From: redrum2 [REDACTED]
Sent: 18 August 2020 19:24
To: Planning <Planning@arun.gov.uk>
Subject: Application Aw/164/20/HH

For the attention of Amber Willard
In respect of 51 Westminster Drive

B~ ROOF OVERHANG ADDED 7/20
A~ CLIENTS REVISIONS 6/20

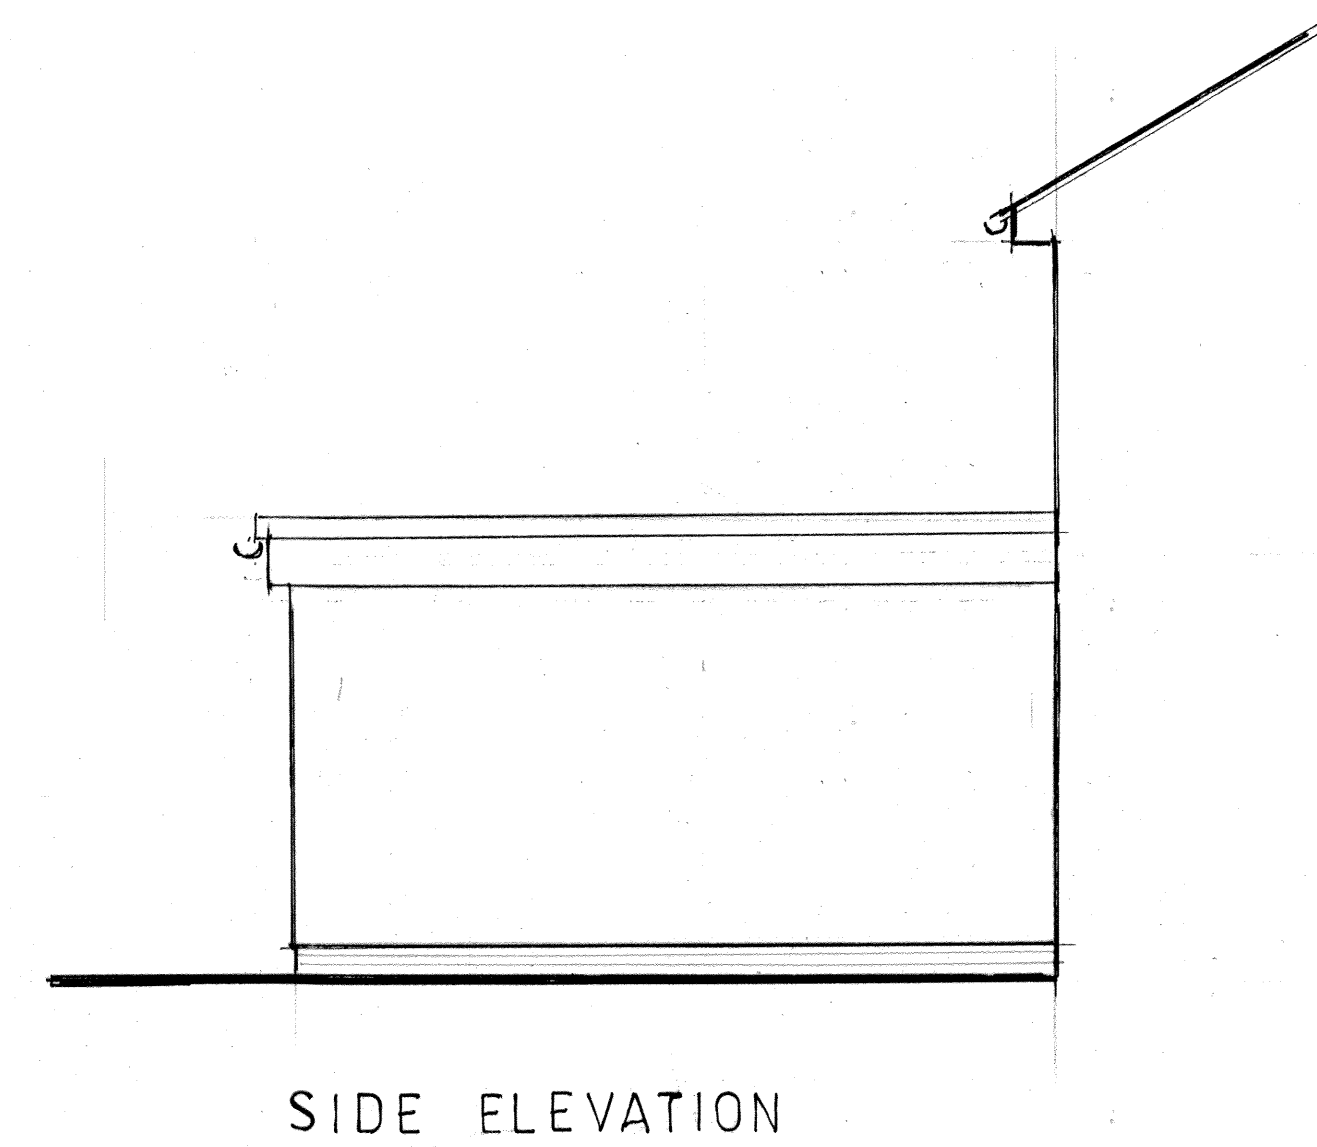
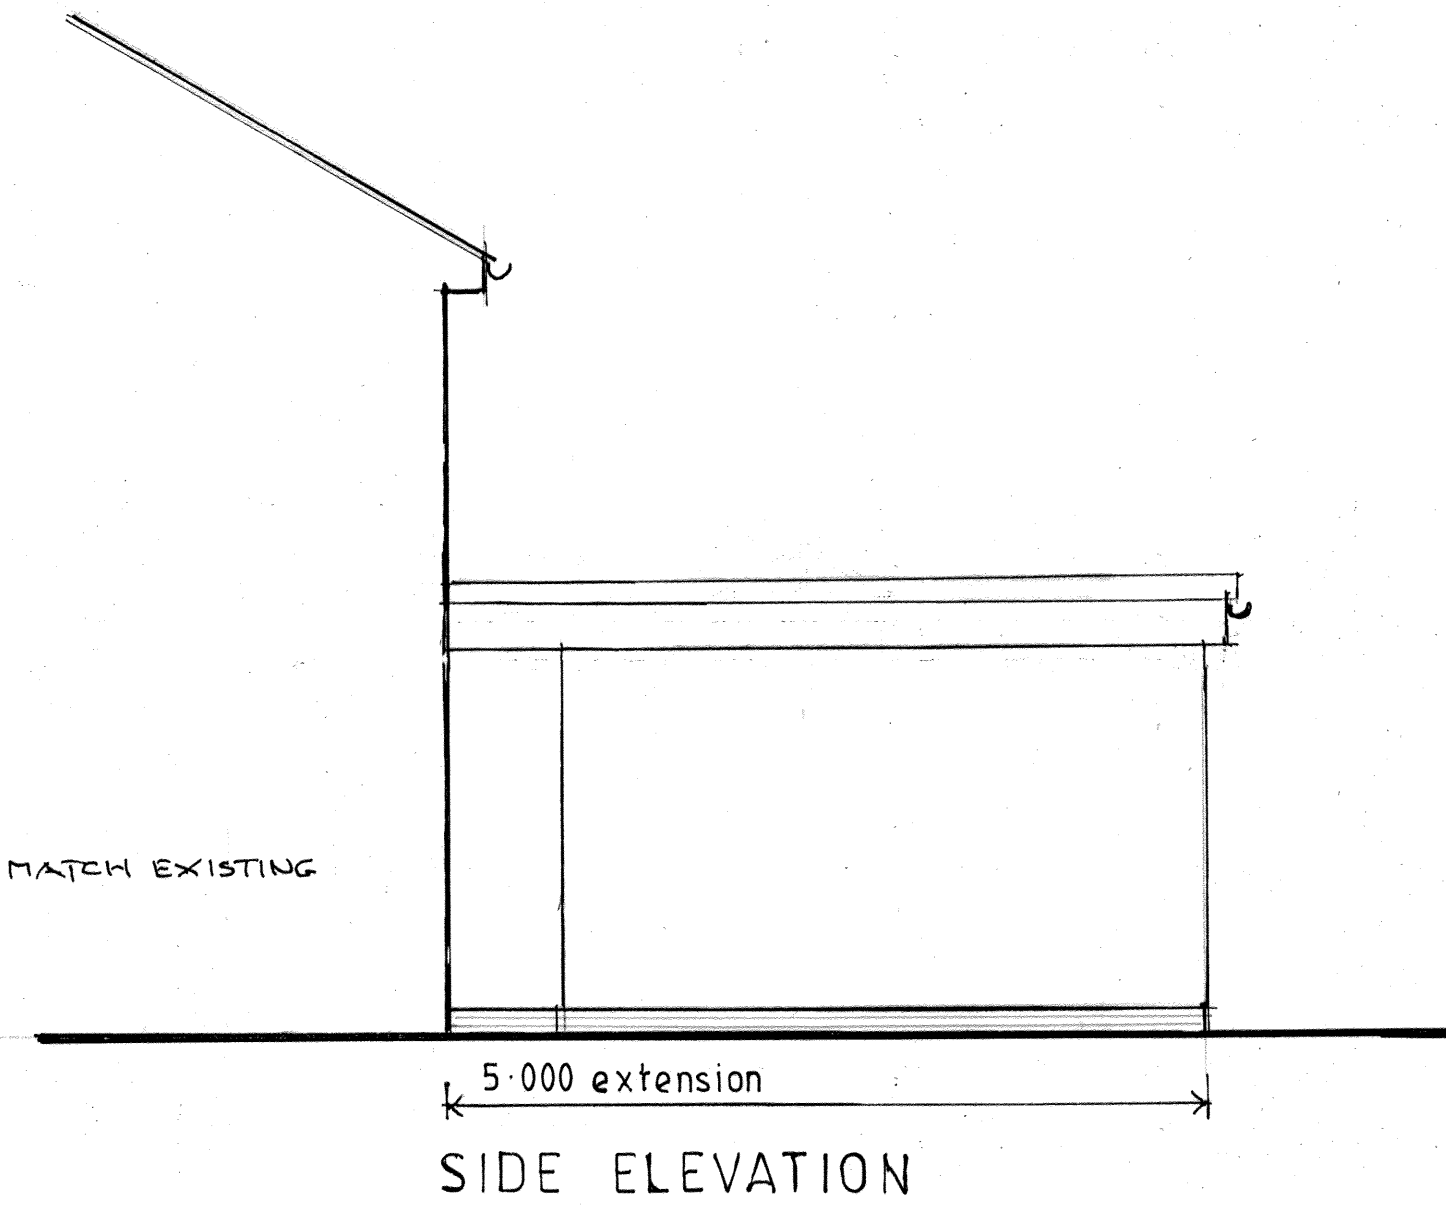
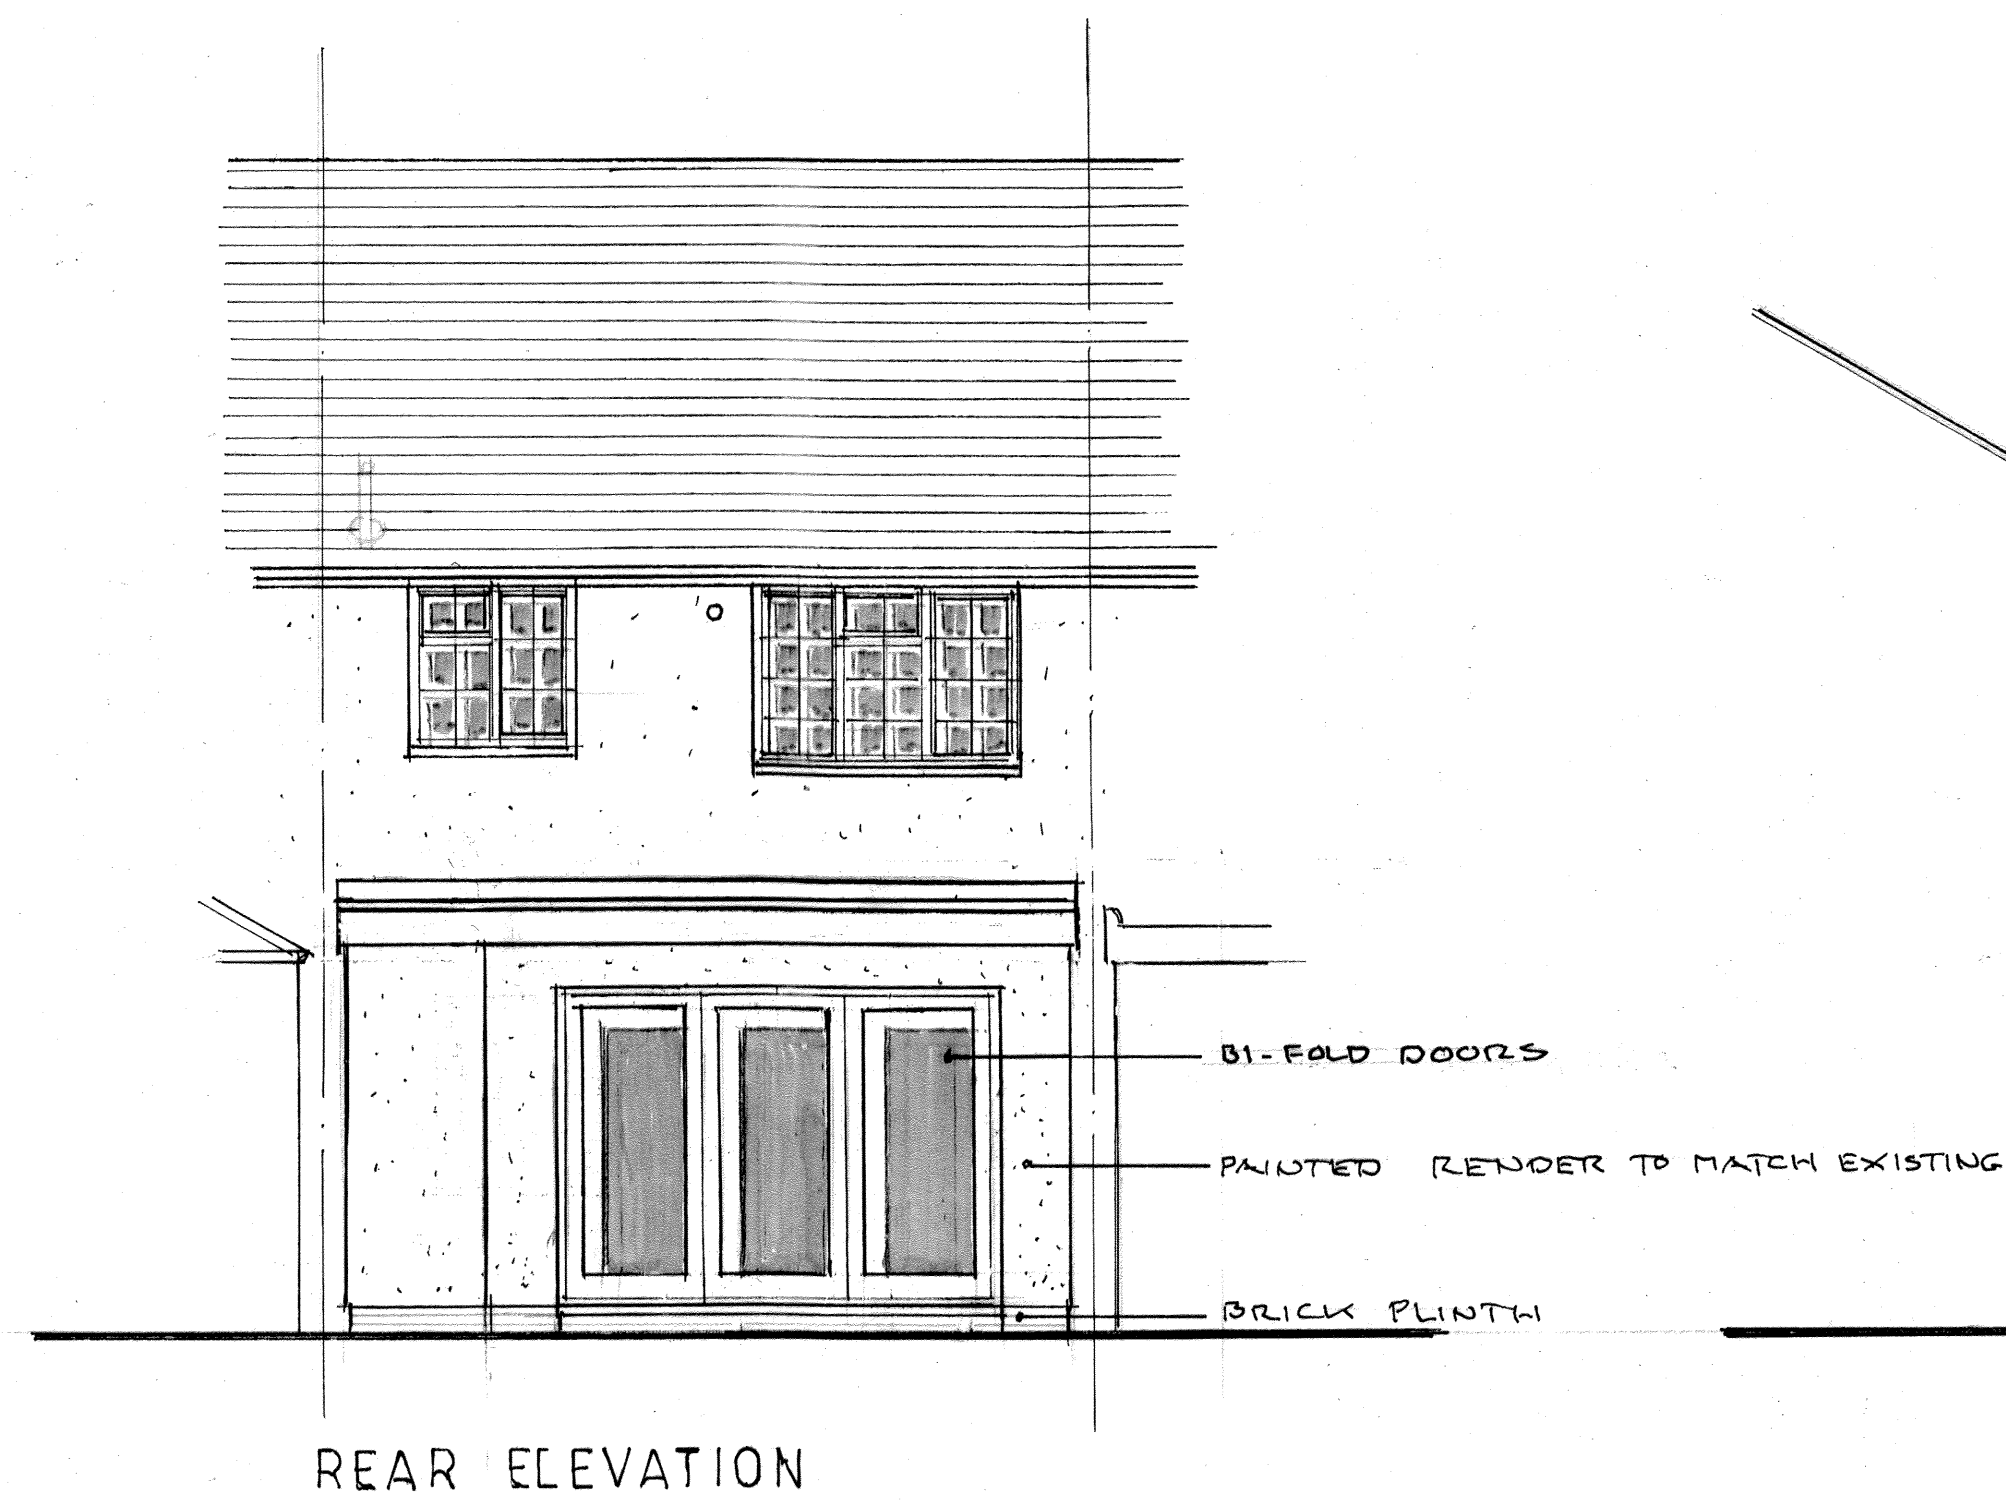
It is mainly the appearance of the Extension it is rather large and stands out with the roof being ugly, besides not matching other properties.
